Our Case Number: ABP-318446-23
Planning Authority Reference Number:

Re: Proposed construction of Coumnagappul Wind Farm consisting of 10 no. turbines and associated infrastructure.
In the townlands of Coumnagappul, Carrigbrack, Knockavanniamountain, Barricreemountain Upper and Glennaneanemountain, Skeeheans, Lagg, Co. Waterford.
(www.coumnagappulwindfarmSID.ie)

Observation Made by : Jacqueline Walsh

Case : Coomnagappal Windfarm, Ballymacarby, Co. Waterford Case No 318446

Drawing Title:
Viewshed Analysis

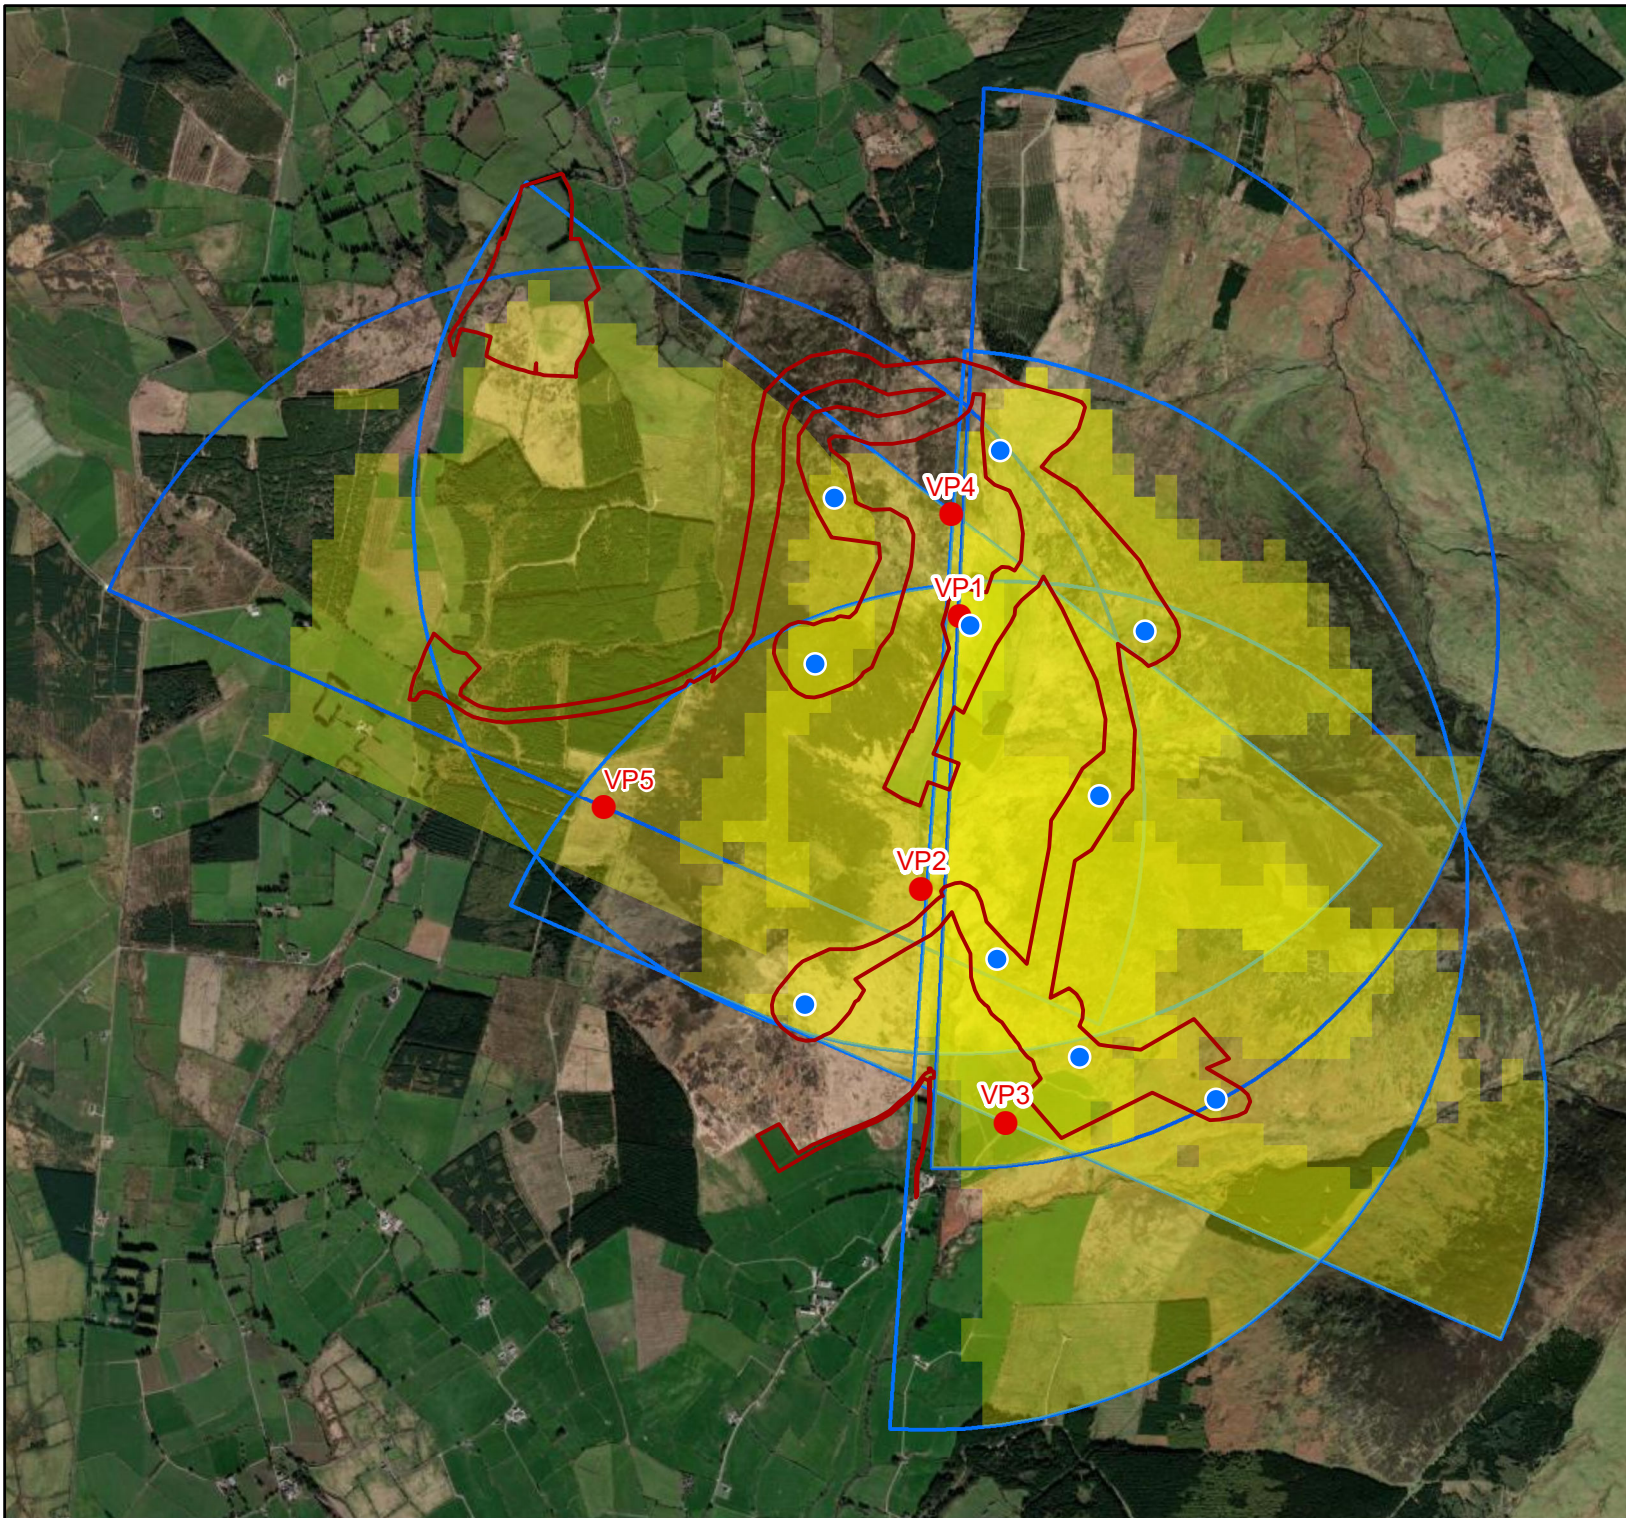
- a. The location of Vantage Points which per the maps provided, a viewshed of 500m beyond the turbine was not achieved for all turbines– despite frequent statements that this was the case

This suggests that a greater area is surveyed than outlined in Chapter 10 – as 500m beyond the development boundary would be greater than 500m radius buffer from the proposed Turbine location. However, neither was actually achieved.

The scale on Figure 6 shows a 500m scale which shows that the viewshed does not extend 500m past the proposed turbine location for Turbines 1, Turbine 2 and Turbine 10. As the flight data from this Vantage Point survey is the key input into the Collision Risk Model, it raises questions as to the integrity of any modelling based on this data which is incomplete.
